From: Holly Duncan
Sent: Thursday, October 12, 2017 3:12 PM
To: Chelsea Benner
Subject: RE: BL-17-00015 Kohl

From: Chelsea Benner
Sent: Tuesday, September 26, 2017 11:08 AM
To: Holly Duncan
Subject: BL-17-00015 Kohl

Hello,
Attached is a new preliminary survey with the location of the wells. Please let me know if you have any further comments.
Thank you!

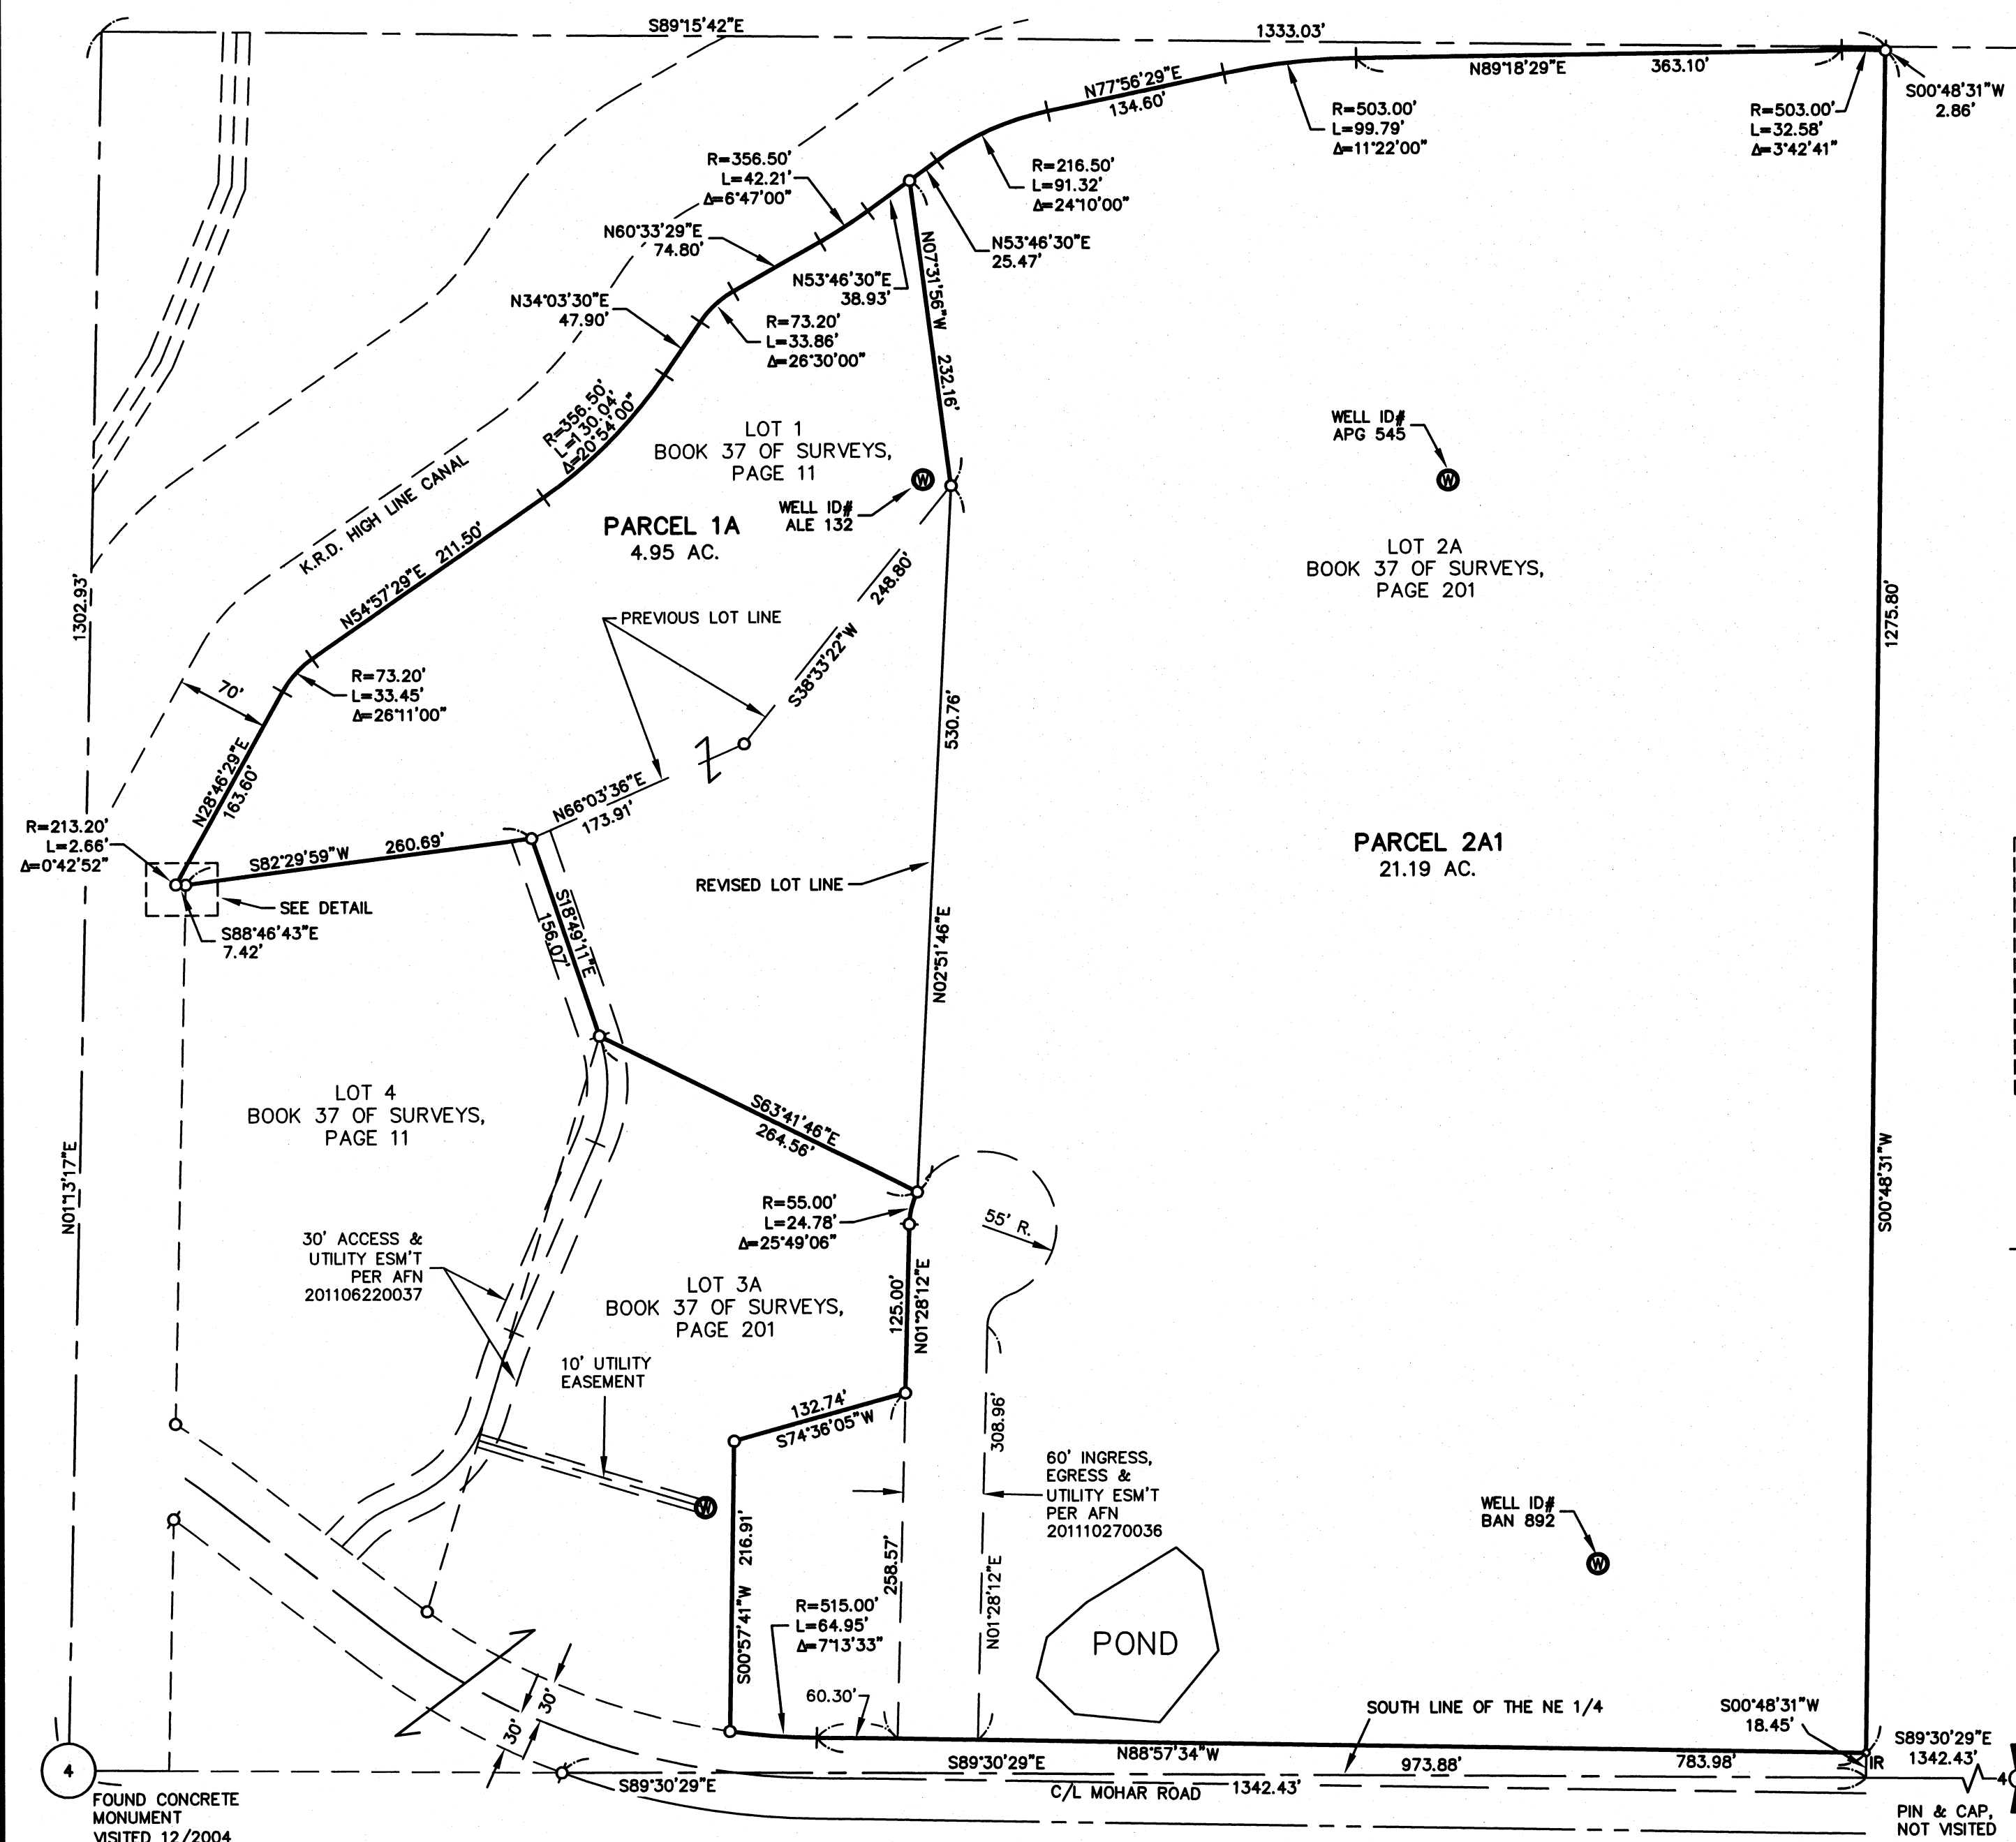
Sure, two of the wells appear to be close to property lines (maybe less than 50 feet). I didn't get back to you because it appears that it may not be an issue as those two wells are not close to any proposed, new property lines.

When you get a minute can you look at the updated survey that you requested for BL-17-00015?
Thank you
